Re: North West Rail Link – Environmental Impact Submission 12/5/12 (SSI-5100);

I object to the proposed location of the Egress facility at Cheltenham Netball Courts.

Figure 6.11 Cheltenham Services Facility light vehicle access and egress

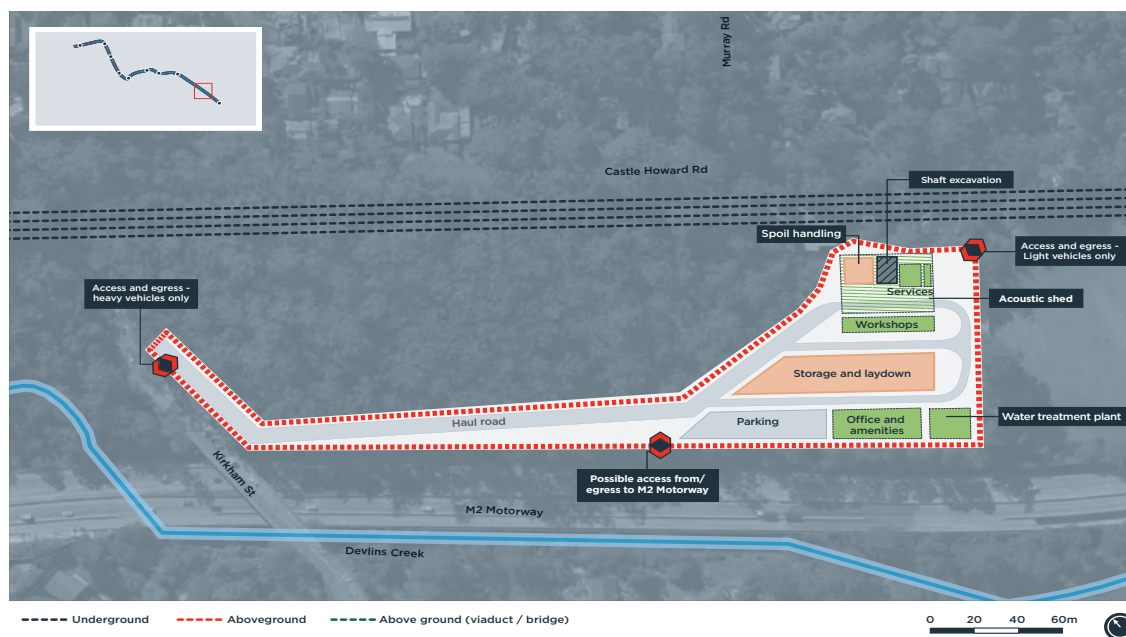
The mistake becomes clearer when we consider that 37 houses will have a visual impact due to the bush land being cleared instead of 5 houses with the Scout Hall option as can be seen in the current EIS provided.

So, I would now like to re-evaluate moving the Service Facility to the Beecroft Scout Hall.

1. Less bushland would need to be removed. A recent visit shows that Welham Street could be extended to the scout hall to allow safe entry to the new facility. Trucks can then be loaded and continue on a one way circuit to Kirkham Street along the existing road used to access the scout hall. This road can be widened with little impact on the vegetation. This option would be far cheaper as well. The area west of Kirkham Street already has a 40m x 20m area that would allow safe exit to Kirkham Street. This would allow a "waiting" area to allow heavy haulage entrance to Kirkham Street.

2. My experience shows that entering the bush towards the Scout hall is far easier than entering the bush towards the netball courts.

It's the line of sight that dictates this. The scout hall entrance is at the top of the hill allowing clear line of sight for oncoming traffic. The netball side is at the bottom of the hill creating impaired vision and down hill braking for traffic in the case of emergency.
